AQUIND INTERCONNECTOR

Statement of Common Ground Between
AQUIND Limited and Historic England

Document Ref: 7.5.13

DATE: 25 JANUARY 2020

EN020022-2.11-PARA-Sheet1	Application document reference 2.11 Optical Regeneration Station(s) Parameter Plan Sheet 1 of 1
---------------------------	--

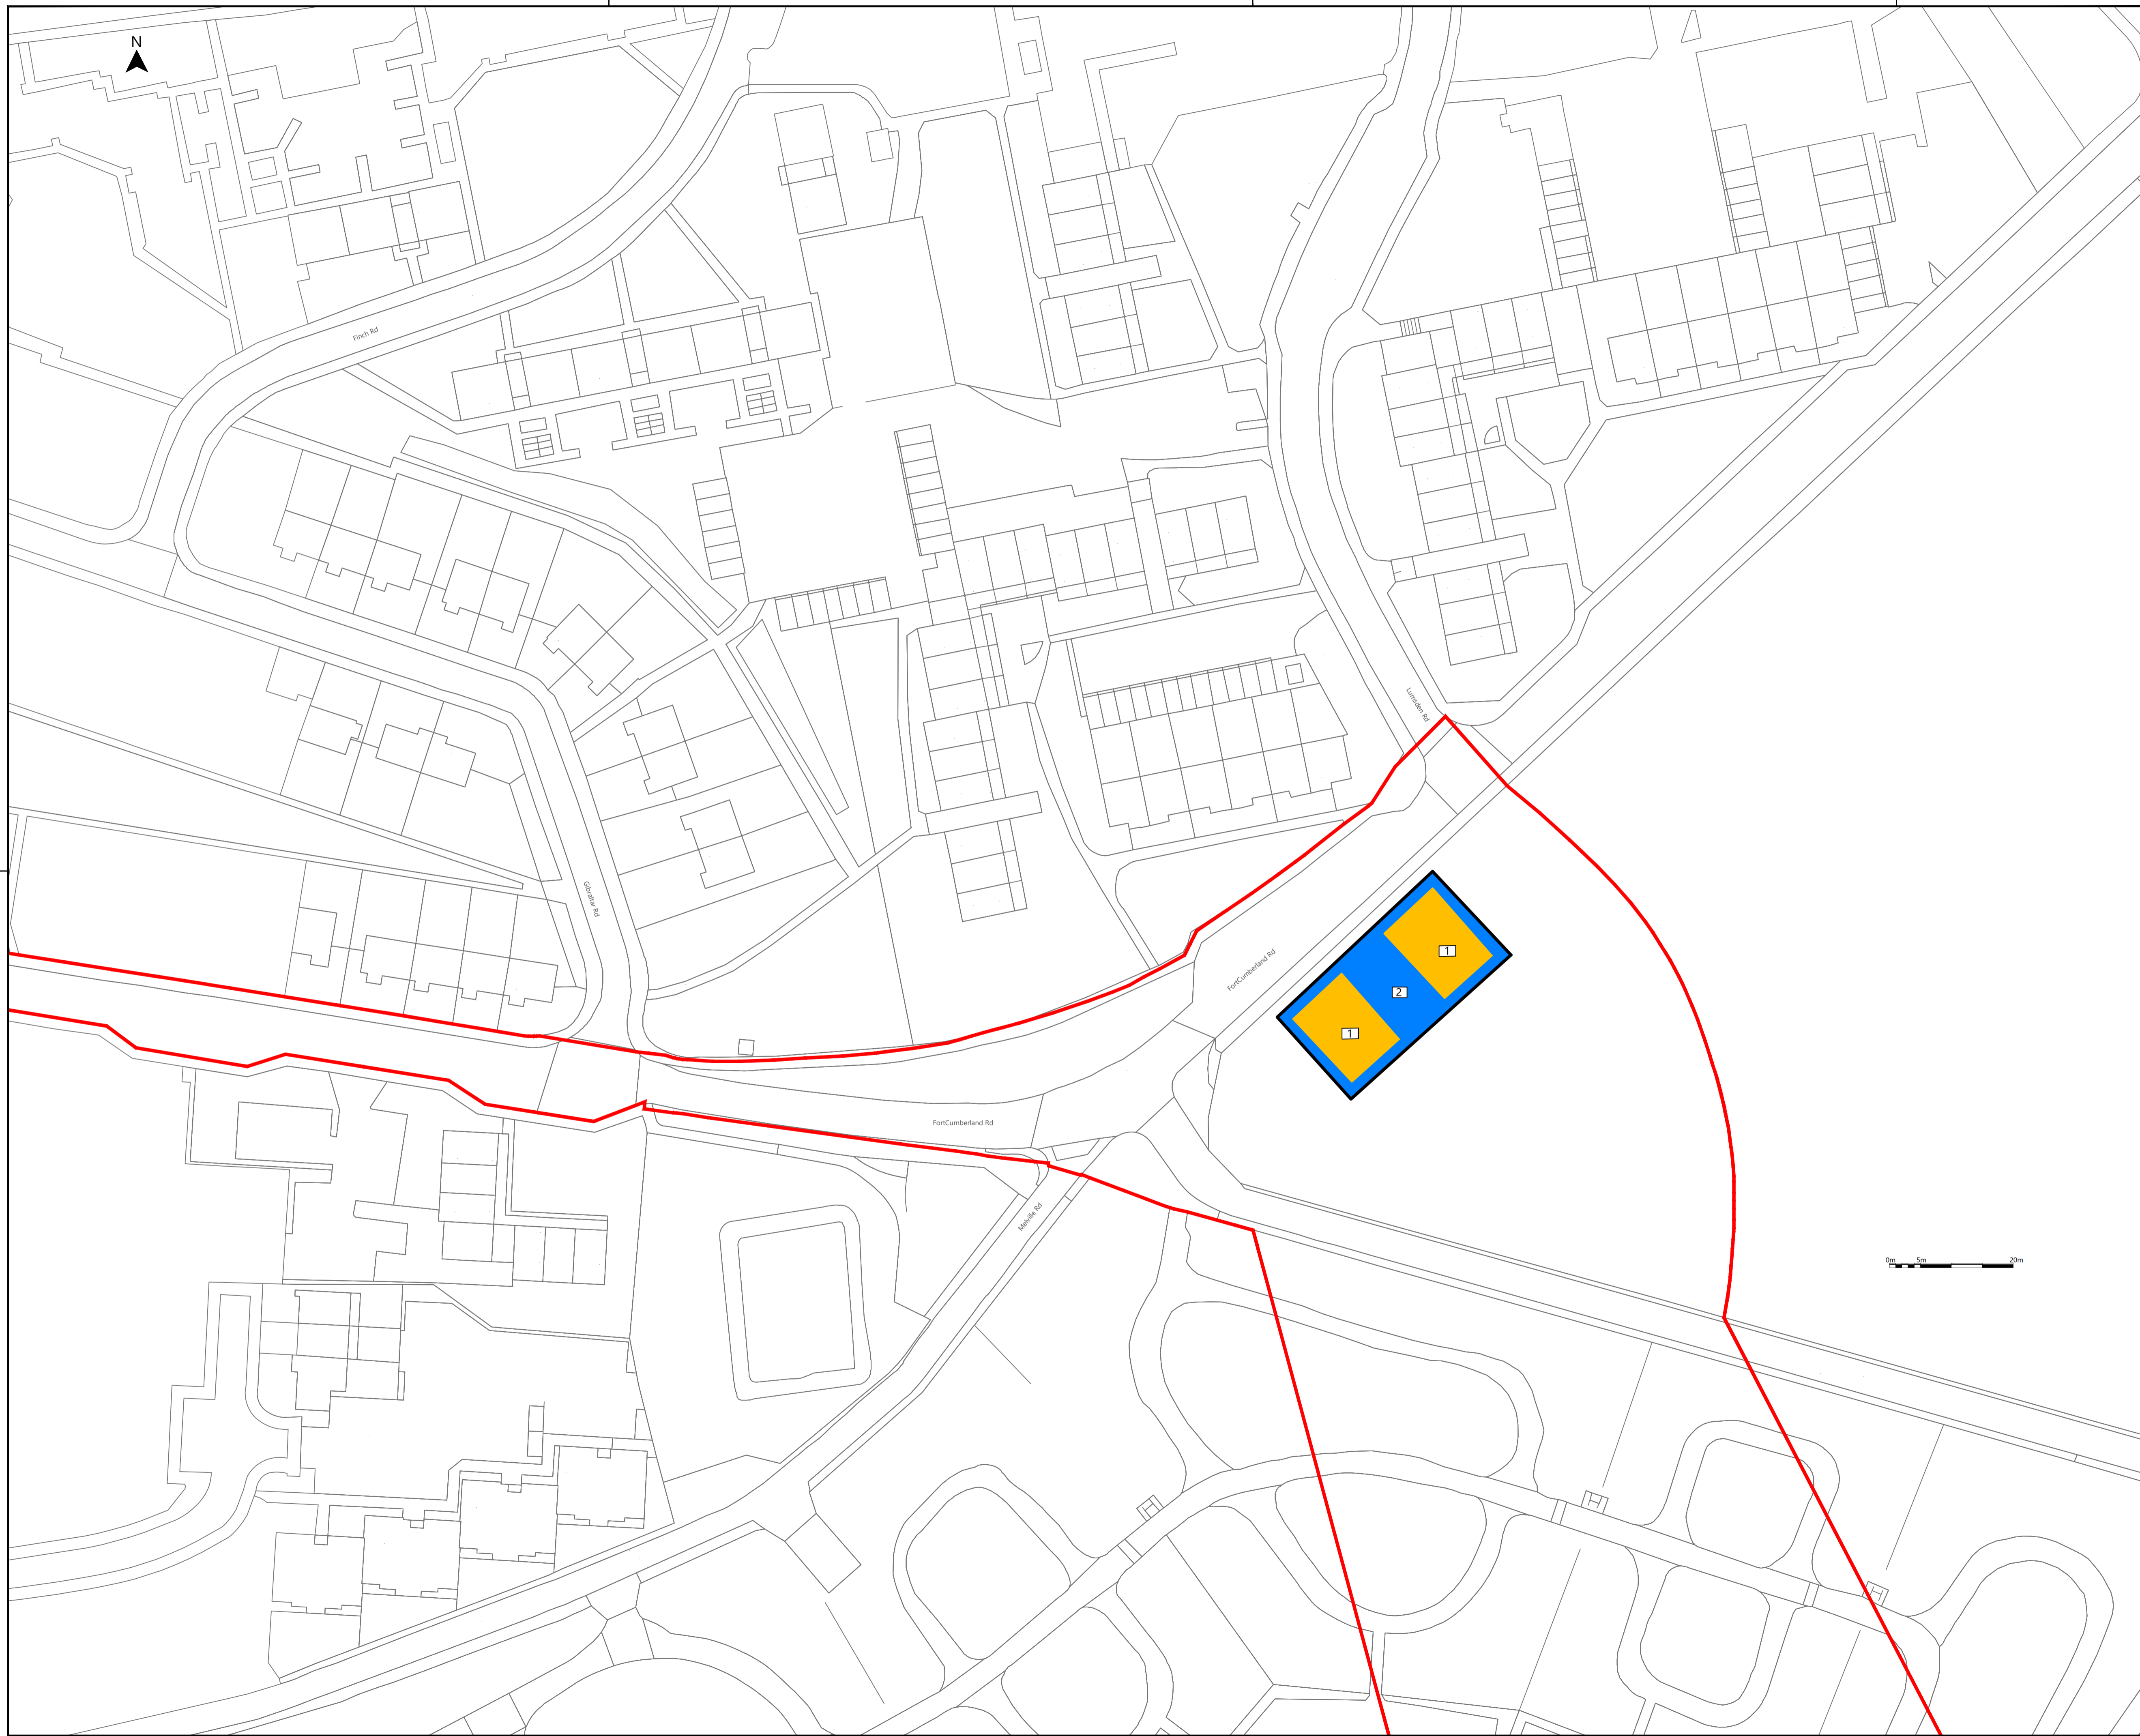
4.1.5	Landfall - Fort Cumberland, Setting (Level of Harm) (2)	<p>AQUIND position:</p> <p>The Applicant considers the impact to the significance of Fort Cumberland is negligible in respect of views from the western ravelin, based on the distance from the asset and the presence of a modern residential housing estate, located 15m to the north-west of the proposed ORS compound. The site of the proposed ORS compound is currently in use as a car park. The Applicant considers that the landward view from the western ravelin has been substantially altered since the construction of a 1960s housing estate (located 15m north of the Proposed Development) and 20th century motor shed adjacent to the north. The surrounding housing estate, trees and parked cars have significantly impacted the open coastal plain in views looking out from the western ravelin towards the Landfall and Fort Cumberland Road, including what were lines of fire from the fort. The location of the proposed ORS compound would introduce a new built form in long views out from the western ravelin towards Fort Cumberland Road. However, the proposed ORS would be lower in height than the current housing estate, and when seen against the background of the surrounding residential development would not be visually intrusive. Taken</p>	Not agreed

Ref.	Description of matter	Details of Agreement	RAG
		<p>appreciate and understand the landward approach to the site, via Fort Cumberland Road in particular, and its relationship with the monument. Historic England request to see the line of sight maintained to maximum extent, through the redesign or repositioning of the ORS.</p> <p>Outcome of further discussions</p> <p>This matter has been subject to further discussion between the parties following submission of the further visualisations contained with the ES Addendum at Deadline 1 (Document Ref 7.8.1). A teleconference meeting was held on 26 October 2020, where the additional submissions were discussed.</p> <p>Based on the additional information provided Historic England do not agree that the level of harm remains negligible and consider the impact to Fort Cumberland as ‘less than substantial harm’ (Overarching National Policy Statement EN-1 terminology). Historic England note that the visualisations do not provide an accurate representation of the view from the western ravelin itself, which is at an elevated position. As such, there is a possibility that the road convergence would be visible over the buildings from the ravelin, but this cannot be confirmed without a viewpoint from the ravelin itself. Historic England consider that the visualisations indicate (combined with viewpoint photos from the ravelin) that there would still be an impact on the view of Fort Cumberland Road even from the higher point.</p> <p>It has been agreed between the parties that the proposed Optical Regeneration Station (ORS) would not result in substantial harm to the Fort Cumberland Scheduled Monument and Grade II* listed building (see 3.1.5). Historic England maintain that the level of harm is less than substantial whilst the applicant considers the overall effect to Fort Cumberland scheduled monument is negligible. Irrespective of this differing professional opinion, in EIA terms the proposed change would not constitute a ‘significant’ environmental effect warranting substantial design amendments to the proposed scheme.</p> <p>The applicant will continue to consult with Historic England regarding reserved matters relating to building design such as materials and palette but do not consider further assessment work necessary. As outlined in Section 5.8 in (EN-1) it will be for the examining authority to decide whether any perceived harm has clear justification, in order to weigh that perceived harm against</p>

09 July 2020	Email	WSP provided an update on progress of the visualisation. It was clarified that the final appearance of the ORS buildings (including materials/colour) would be determined post consent with the submission of a detailed design within the defined parameters plan, which would be subject to local authority consents.
21 July 2020	Email	Merged onshore and marine SoCG issued to Historic England for review.
21 August 2020	Email	WSP provided detail of increased visualisation scope (comprising 4 separate wirelines, rather than the single block parameter), for Historic England comment.
24 August, 01, 04 September	Email	Various correspondence confirming next steps and timescales for delivery of visualisation.
